Designer's Response

Project	23314
Project Number	Wicks Farm Glasshouse and Reservoirs, Ford
Comments Received from	Paul Cann
Date Comments Received	4 May 2021
Date of Response	29 June 2021

Title
CONSTRUCTION DETAILS

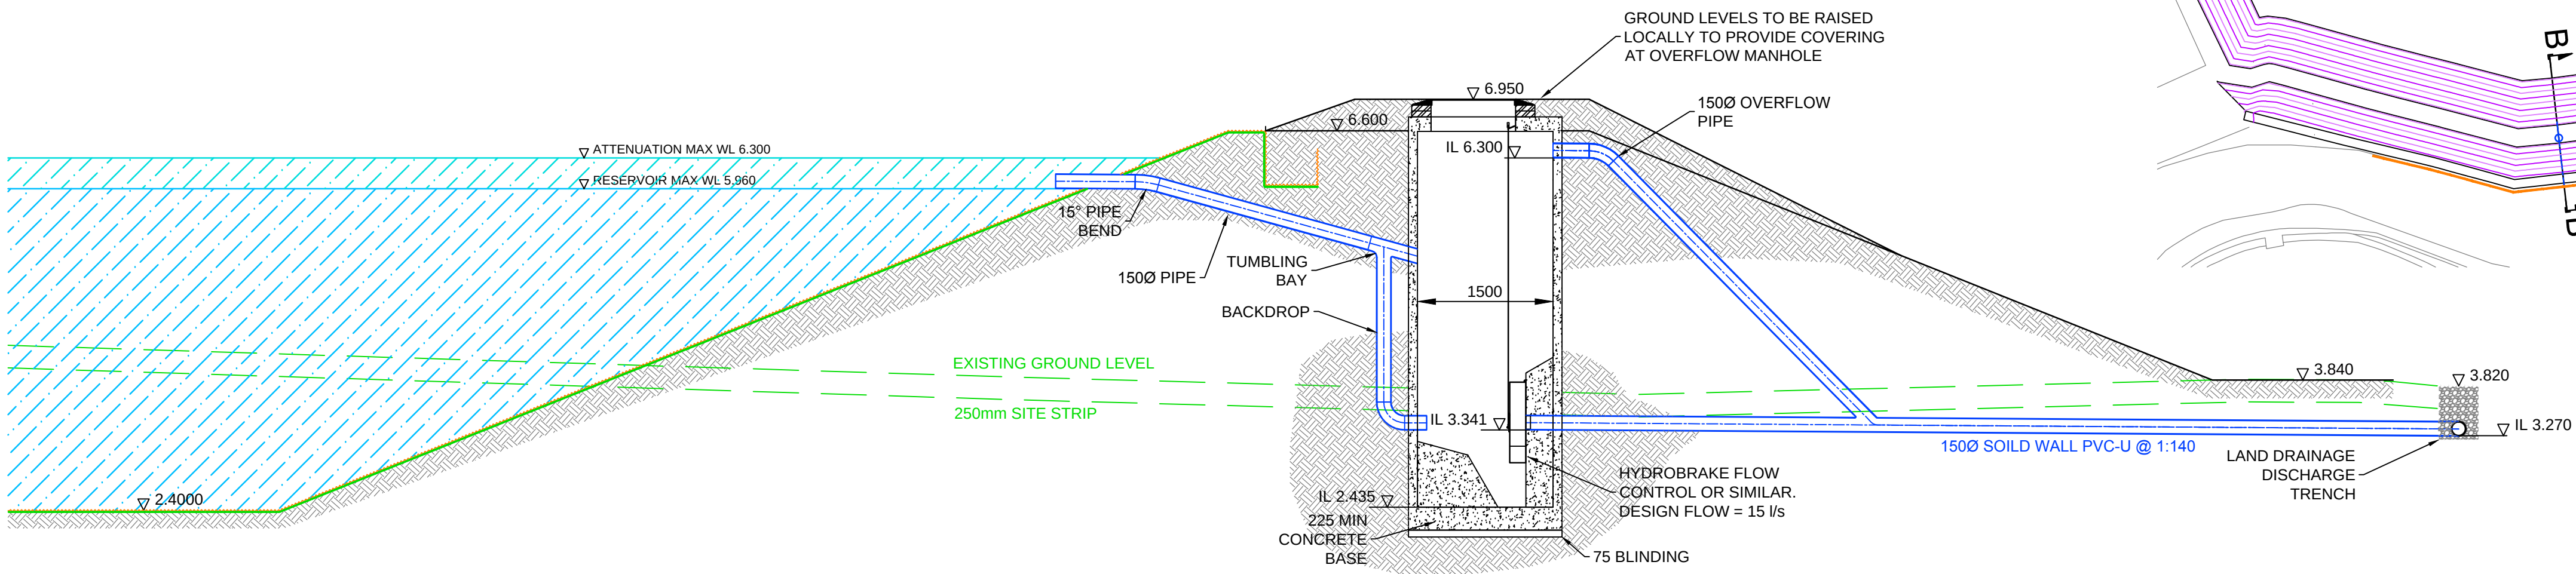
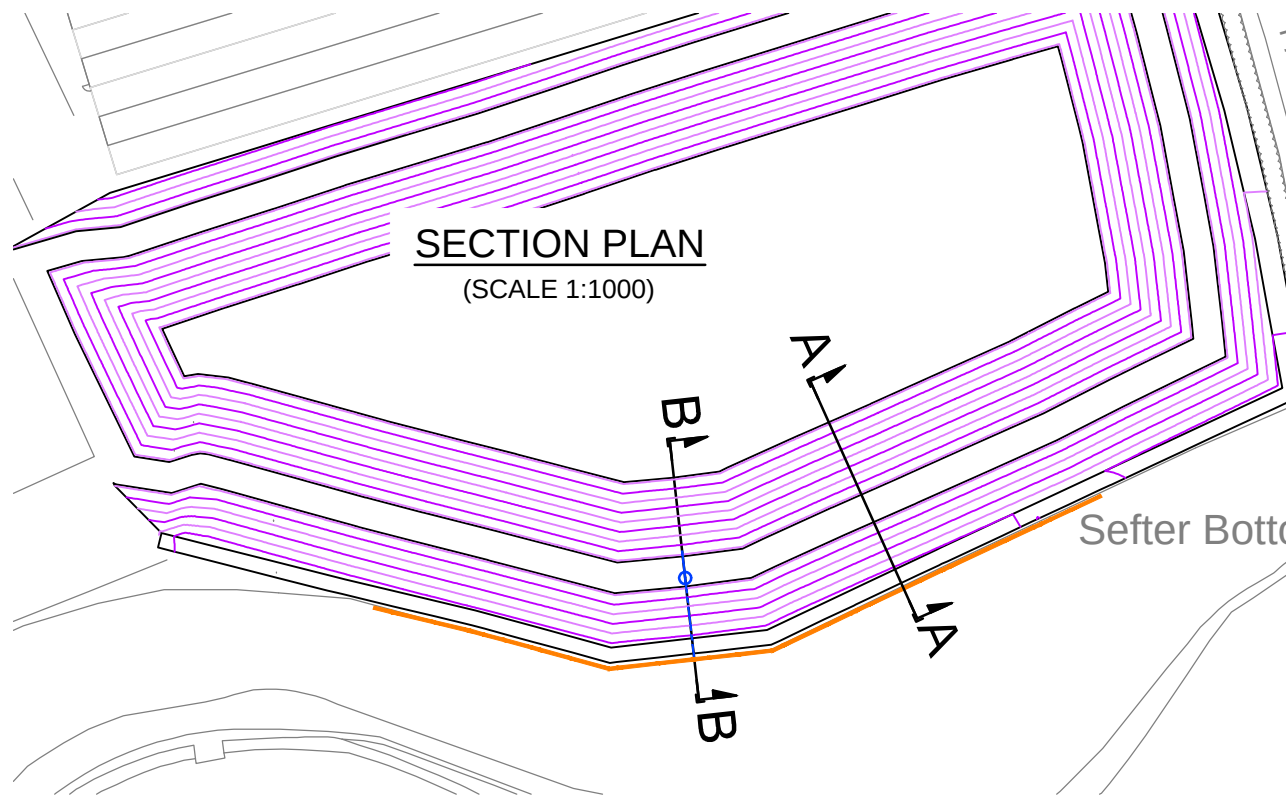
Comment / Query	Designer's response
3 Reservoir Outlet pipe level, planning granted at 3.850m AOD, as built level is 4.100m AOD.	This reduces the available storm water storage volume above required irrigation water by 250mm across the reservoir. We propose that a second outlet to the hydrobrake manhole is constructed at 3.85m AOD and the current outlet is removed.
4 Reservoir Hydro brake, planning granted for a discharge at 20/l/s, as built hydrobrake restricted to 13/l/s.	This is a reduction below greenfield runoff and will also affect the requirement for storm water storage the requirement for which will have been increased as a result. We propose the hydrobrake is changed to the planning agreed model with an outlet of 20l/s.
Swale inter connections as pointed out on site are different, installed 1 x 450mm, Planning 2 x 600mm. Originally there were far more yard concrete planned and is currently still shown on the planning drawings. The as built surface area run off to the front of the site is far less so therefore water flow through the ditch and swales reduces significantly.	This refers to the storage swale at the southwest side of the site. A reduction from 2x600mm to a single 450mm pipe is considerable. We propose that the 450mm pipe is replaced with the planning approved twin 600mm pipes or that 3 additional 450mm pipes are added to the existing 450mm pipe to allow the same conveyance.
